Public Submissions Response

State Significant Development SSD-17424905
Pymble Ladies College – Grey House Precinct
20 Avon Road, Pymble (Lot 1 DP 69541)

6 SHADOW DIAGRAM PROPOSED June 21 - 12 30PM
1 : 1000

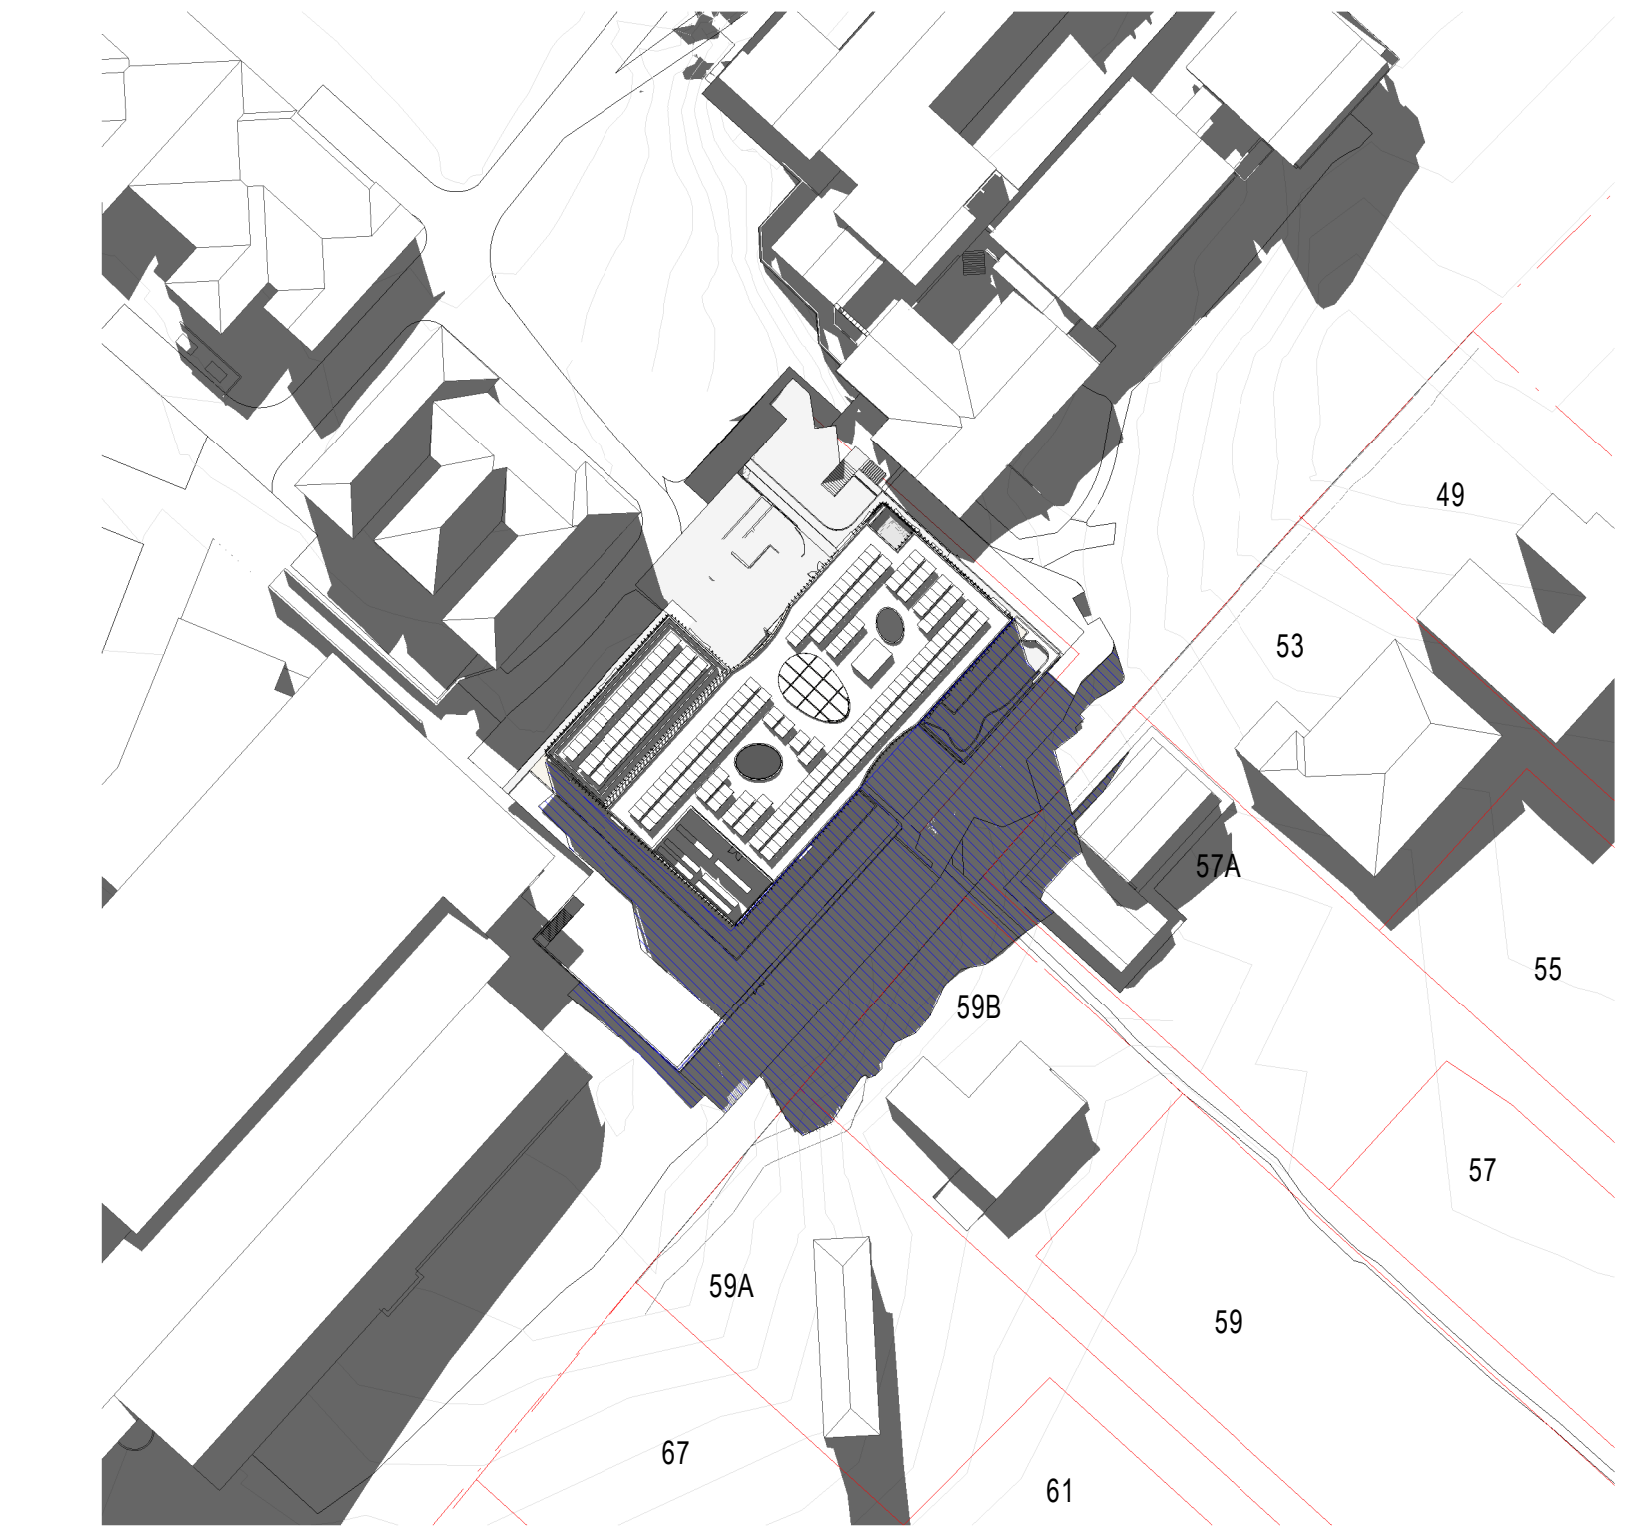
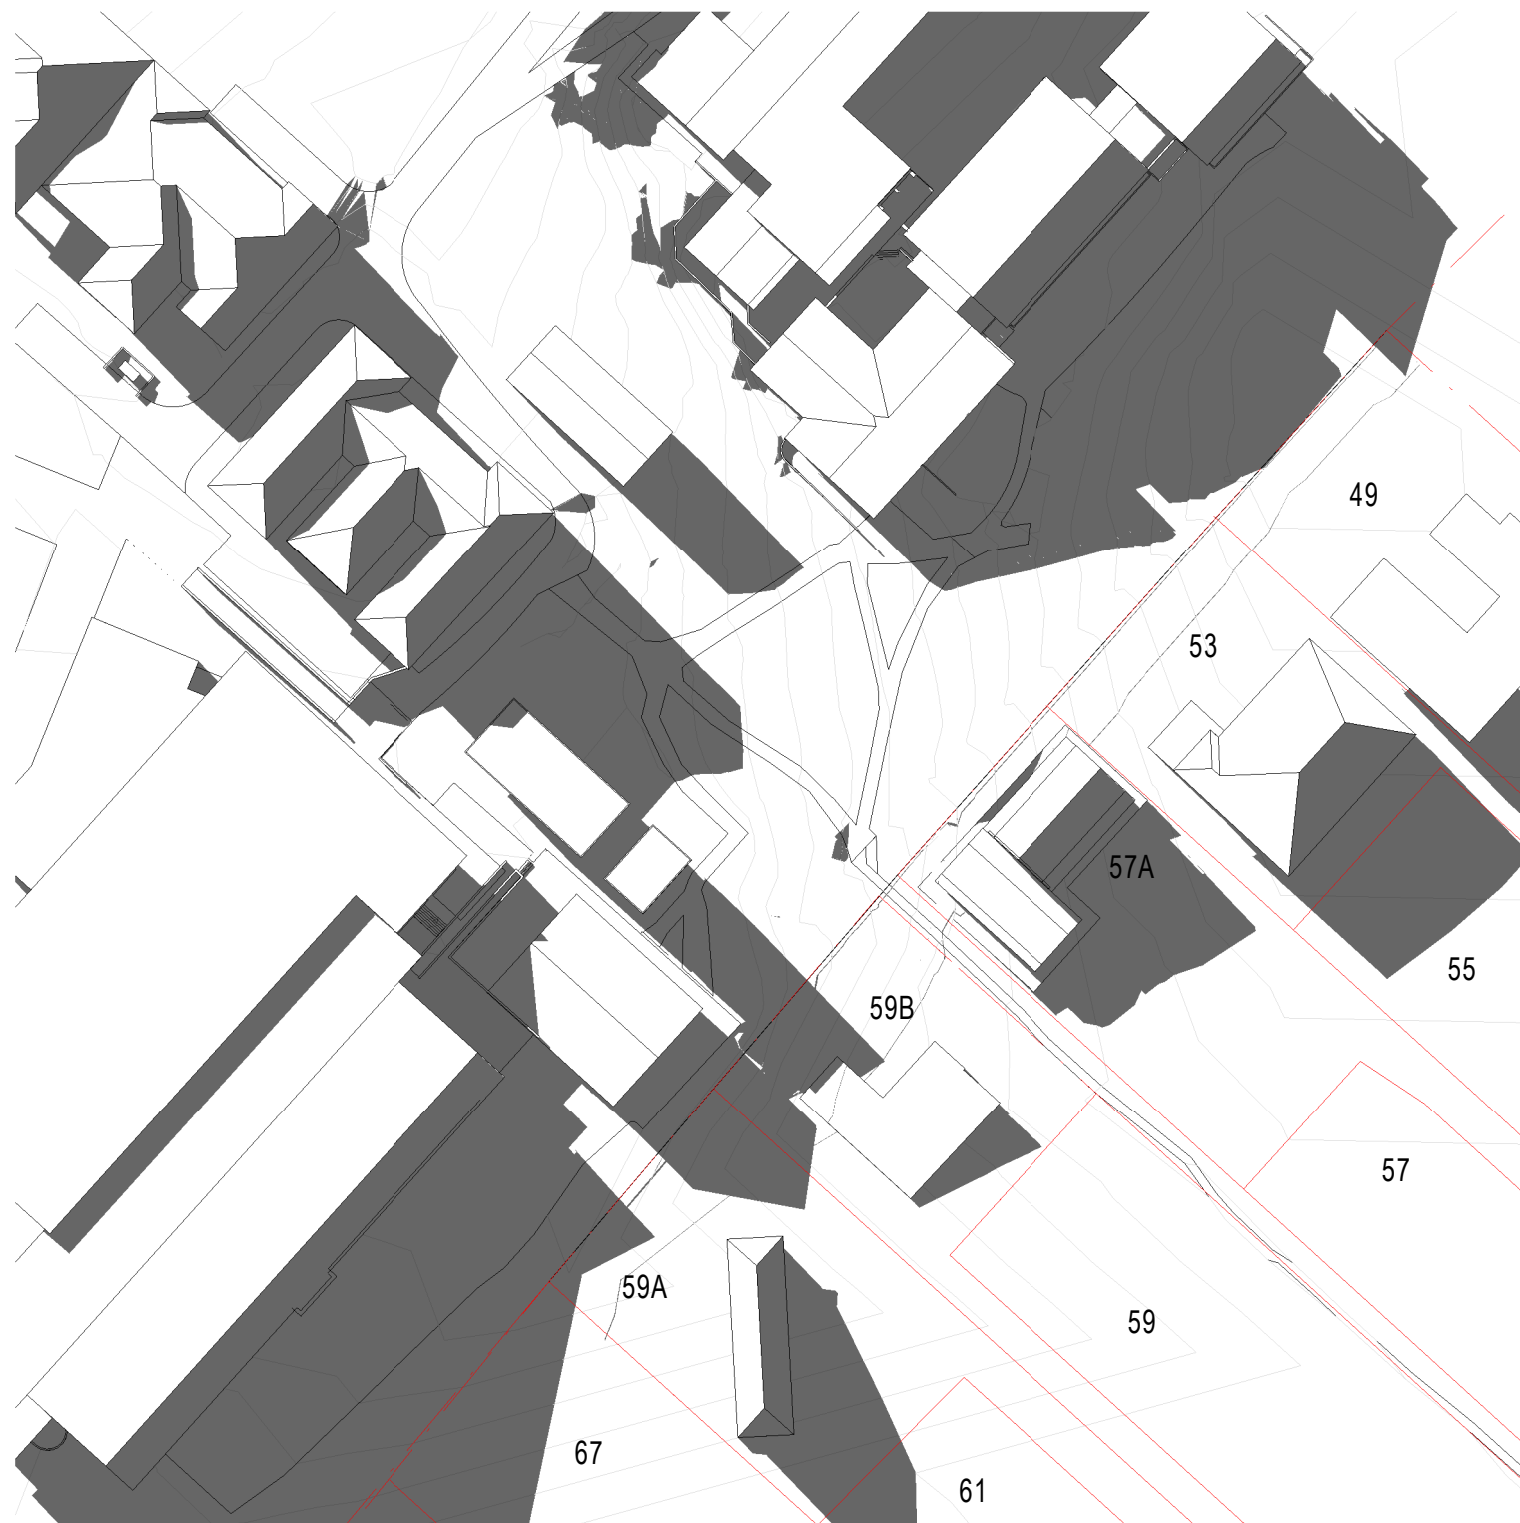
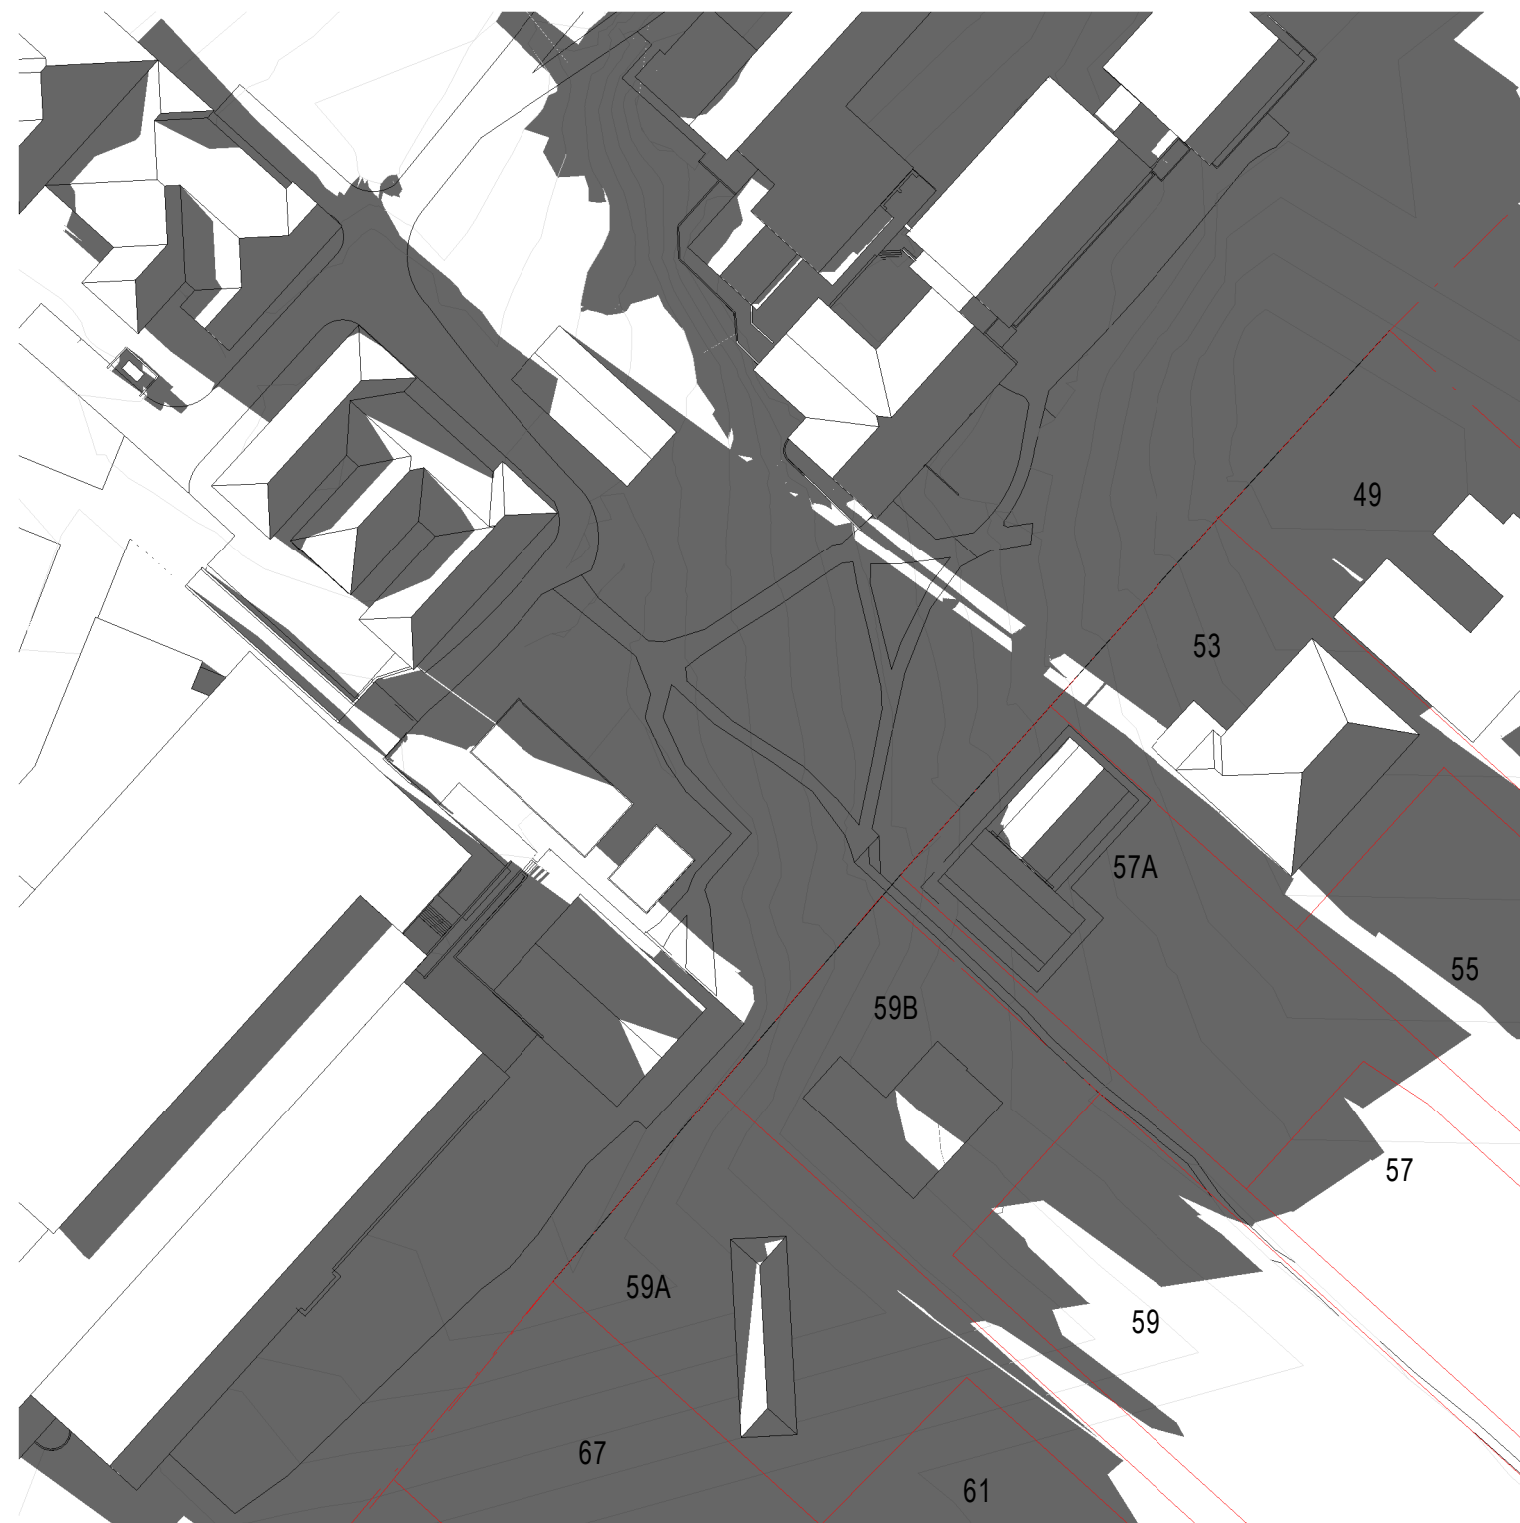
<p>Building Height</p> <ul style="list-style-type: none">- The building height is contrasting to the surrounding 1-2 storey buildings- The upper floors of the building create bulk, overshadowing and privacy issues- The proposal is contrary to the KLEP2015 objectives in relation to establishing a transitional scale between centres and adjoining lower density residential spaces to protect local amenity as well as enabling development with a built form that is compatible with the size of the land.	<p>The proposed building has been designed to minimise the perceived scale and height. Given the surrounding topography, the building presents as differing building heights and is further broken up by horizontal and vertical façade articulation and use of different materials.</p> <p>The proposed development has been amended to further reduce the perception of bulk and scale, through increasing the brick podium base, setting back the upper storey of the building, increasing the scalloped entrance detailing and utilising additional different</p>

<p>materials and the additional of horizontal elements to break down the building.</p> <p>Substantial testing has been undertaken on the solar access to the nearby residences, and it is considered that these residents would still receive ample solar access to living and private open spaces. This is consistent with the relevant State and Local guidelines in relation to solar access.</p> <p>The vertical fins, substantial setback and topography limit the ability of overlooking into the neighbouring properties. Detailed sight lines have been provided in Attachment A and B. The upper levels have minimal potential for overlooking, however these are the health rooms and would not have large numbers of students in them. Further substantial landscaping has been provided along this boundary which assists in improving the residential outlook and further limiting impacts on privacy of the residents.</p>
